WEST SUSSEX COUNTY COUNCIL CONSULTATION

TO:	Arun District Council FAO: Mrs A Gardner
FROM:	Highways, WSCC
DATE:	24/09/2018
LOCATION:	St Marys Close, Hurst Road, Rustington, BN16 3AP
SUBJECT:	R/190/18/PL Demolition of 1 No. existing house & grounds & erection of 2 No. new detached dwellings. This application may affect the character & appearance of the Station Road, East Preston Conservation Area.
DATE OF SITE VISIT:	
RECOMMENDATION:	☒ Advice ☐ Objection ☐ Modification ☐ No Objection ☐ More Information ☐ Refusal
S106 CONTRIBUTION TOTAL:	£N/A See below for breakdown.

Drawing Title:
ADDITIONAL DWELLINGS
BLOCK/ SITE PLAN

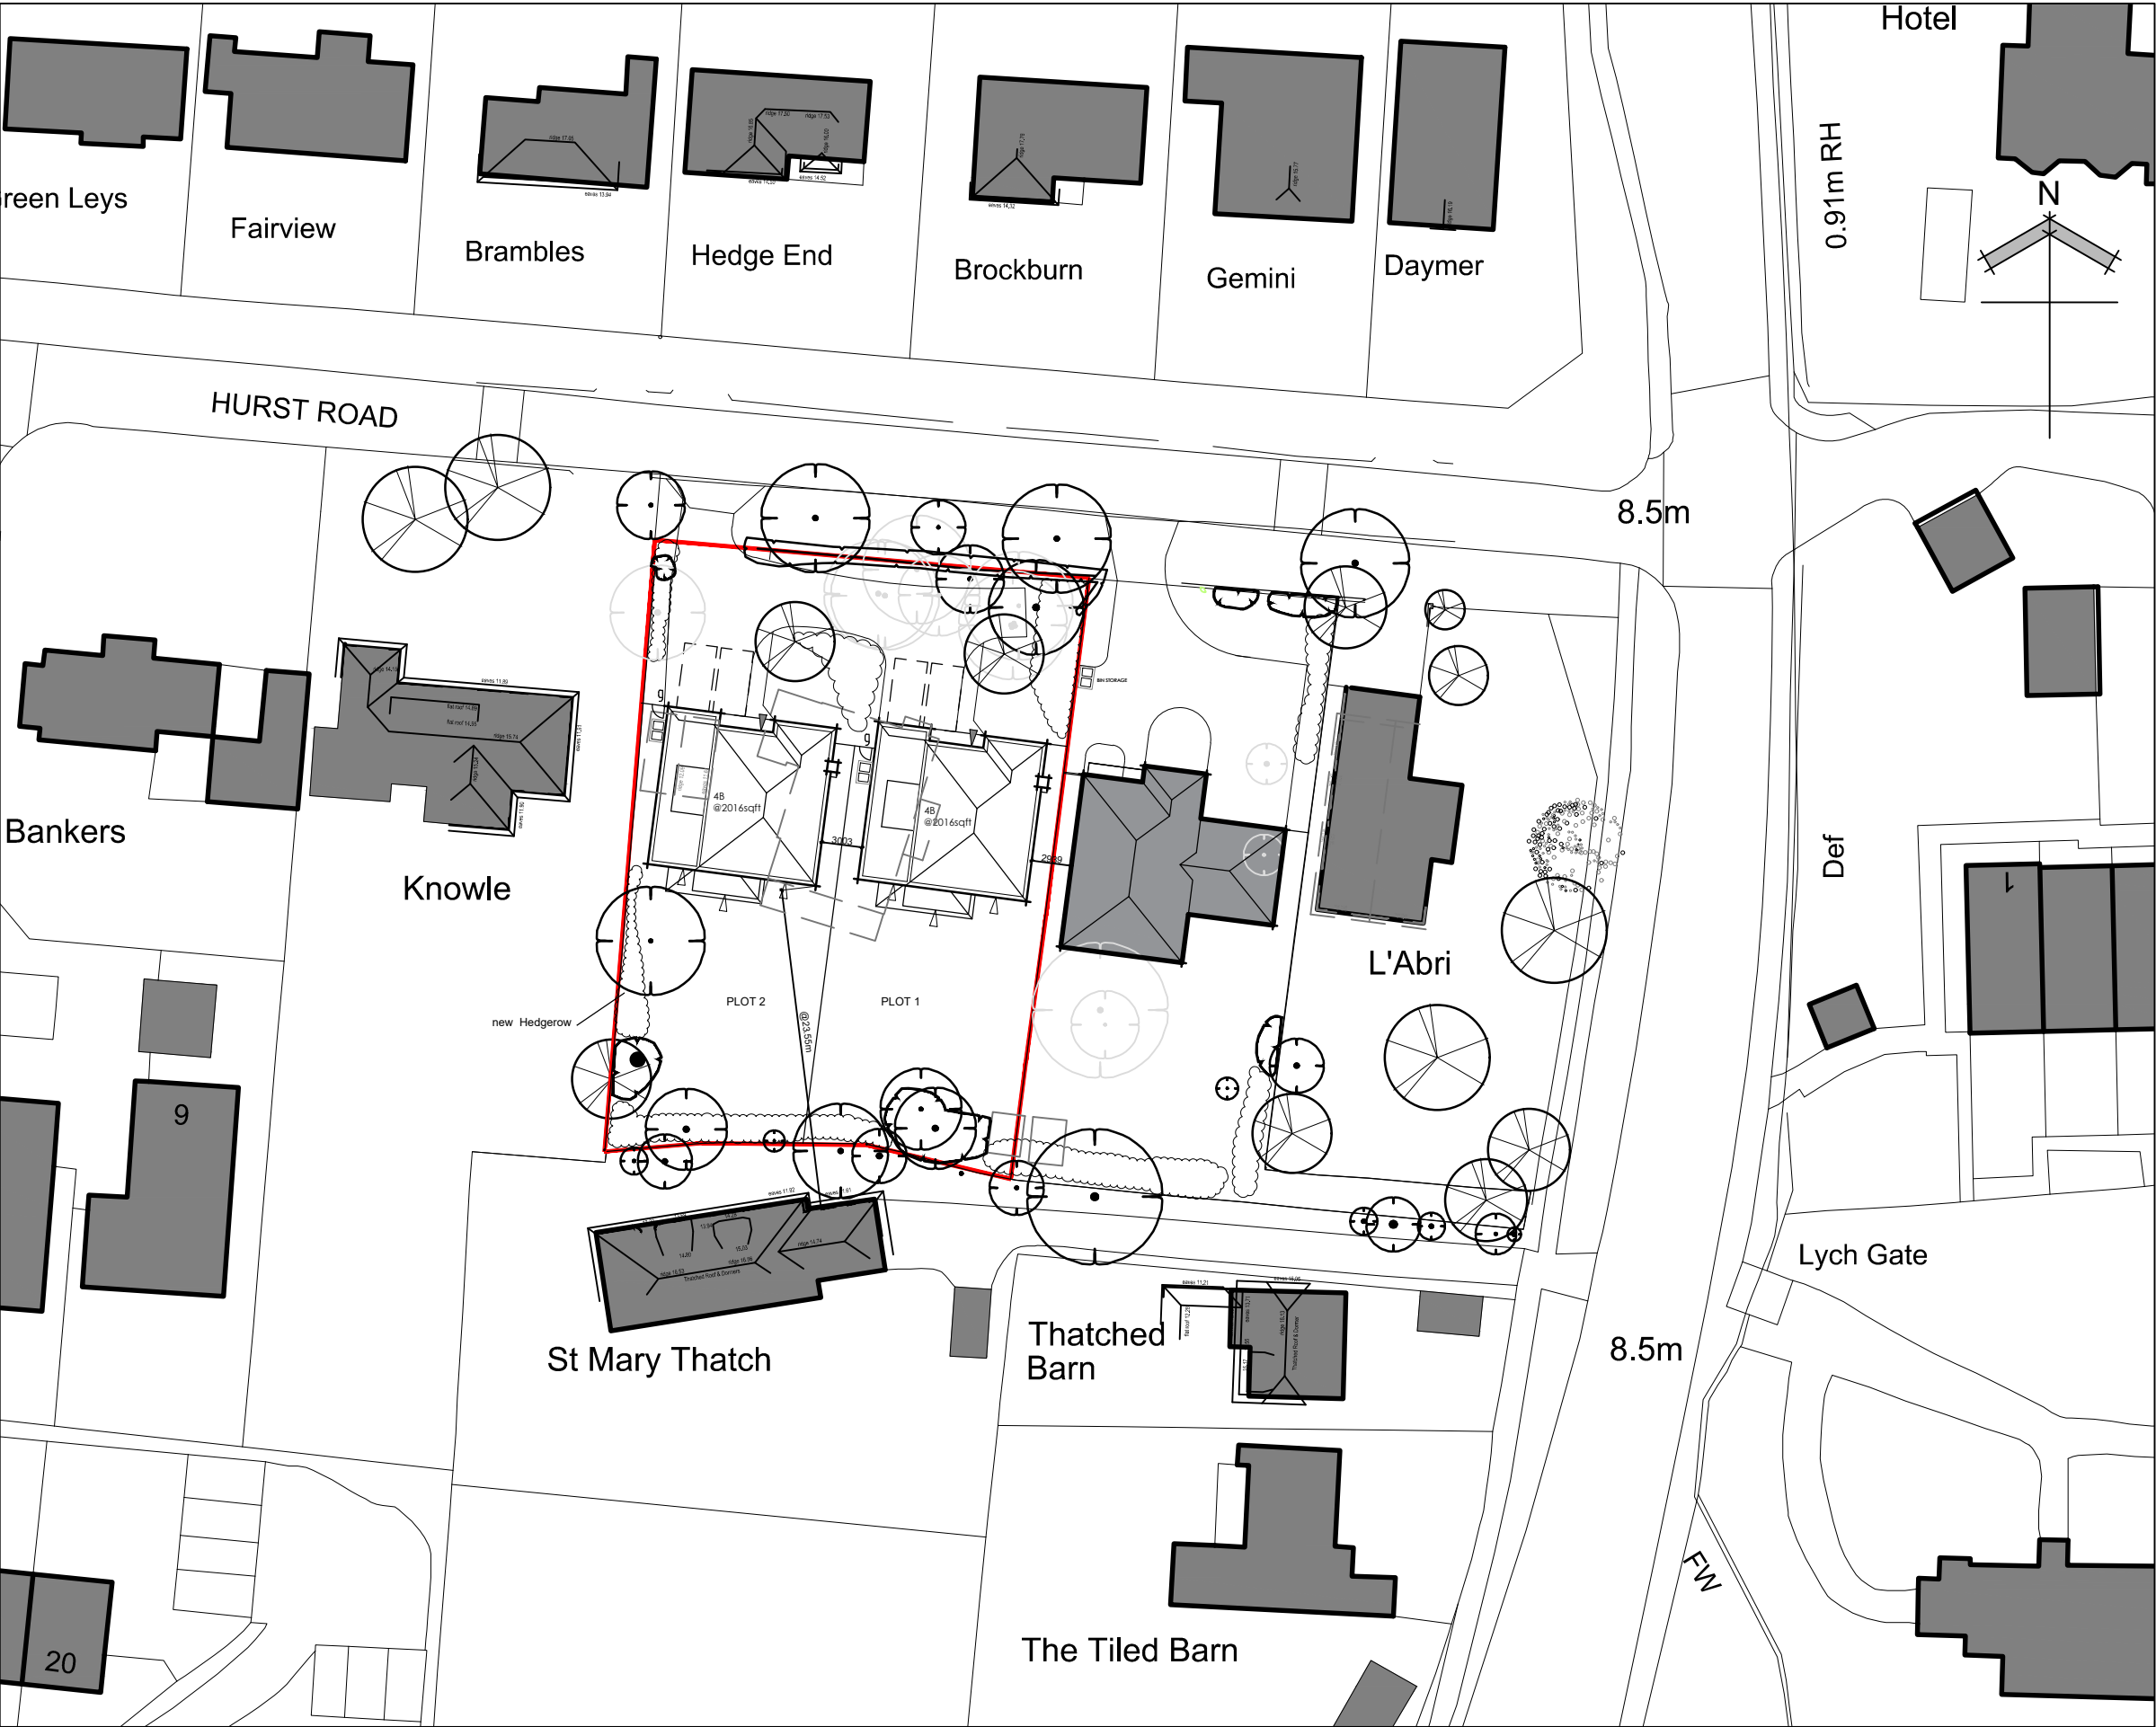
The site is accessed from Hurst Road, a privately owned road. No changes have been proposed to the existing site accesses, although both dwellings will be accessed through one access, with the other utilised solely by the dwelling proposed in application no. R/219/17/PL. The nearest publically maintainable highway is Station Road, a 'B' class road with a speed limit of 30mph in this location. The Local Highway Authority (LHA) has reviewed data supplied to WSCC by Sussex Police over a period of the last five years. There have been no recorded injury accidents at the junction between Hurst Road and Station Road. There is no evidence to suggest that the junction is operating unsafely, or that the proposed dwellings would exacerbate an existing safety concern.

The WSCC car parking calculator would envision a total of 7 car parking spaces for the two proposed dwellings. The applicant has proposed 8 car parking spaces, 4 within garages and 4 on the frontage. The garages would appear capable of accommodating 2 car parking

spaces and cycle storage. The 4 car parking spaces on the frontage all measure approximately 2.4m x 4.8m and can therefore be counted towards parking provision. The LHA would anticipate that there would be sufficient space on site for vehicles to turn to exit in a forward gear.

The LHA does not consider that the proposal for the demolition of an existing dwelling and construction of 2 new dwellings would have 'severe' impact on the operation of the Highway network, therefore is not contrary to the National Planning Policy Framework (paragraph 109), and there are no transport grounds to resist the proposal. If the Local Planning Authority (LPA) are minded to approve the application the LHA would recommend that conditions securing cycle parking and car parking and turning are included.

Drawing Title:
ADDITIONAL DWELLING
plots 1 & 2
FLOOR PLANS

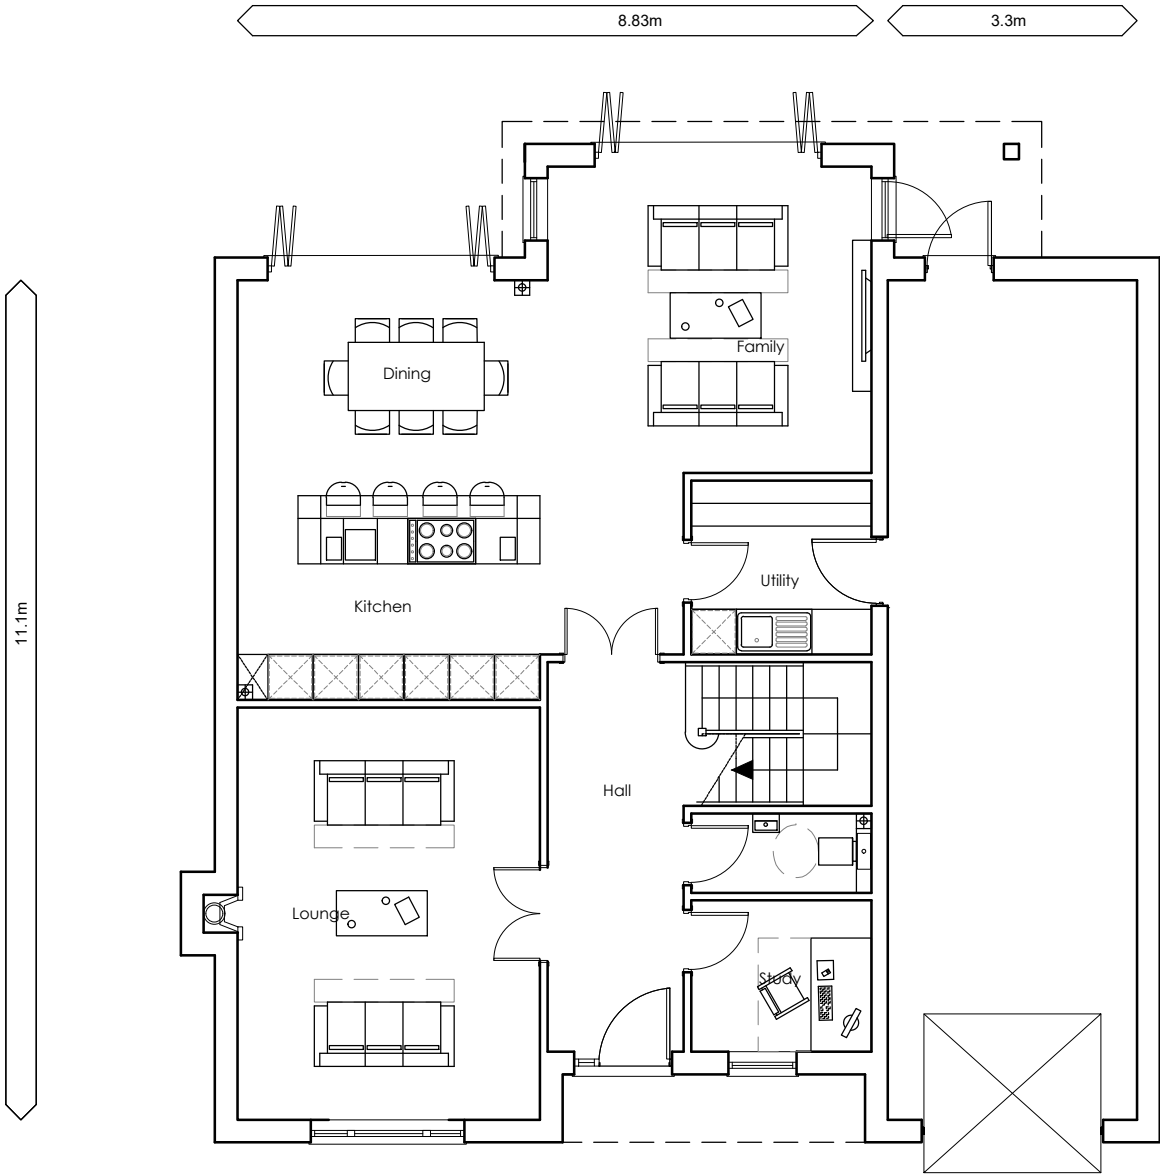
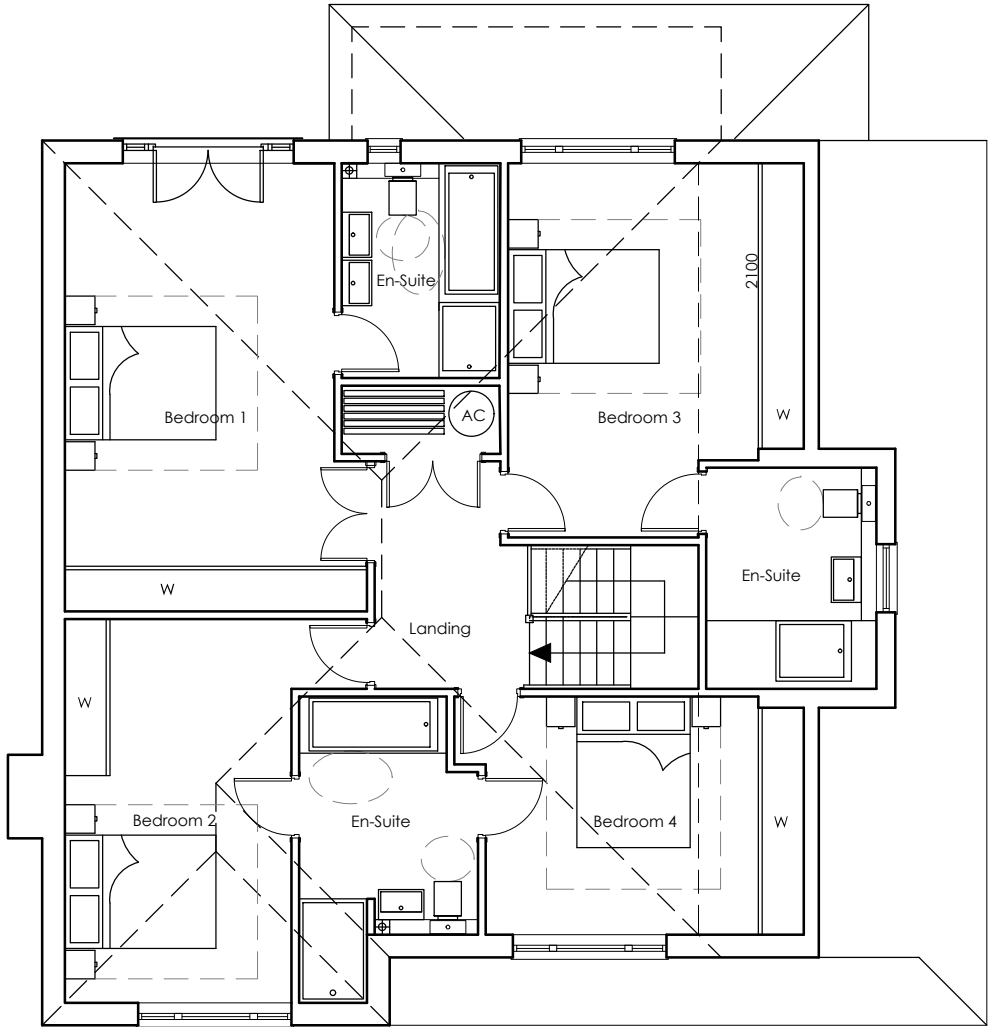
The site is an approximate 3 minute bicycle ride from Angmering train station. Local shops and amenities are located approximately a 5 minute walk from the site, with bus stops within a few hundred metres from the site. The LHA notes that there would be sufficient space within the proposed garages to provide secure and covered cycle storage.
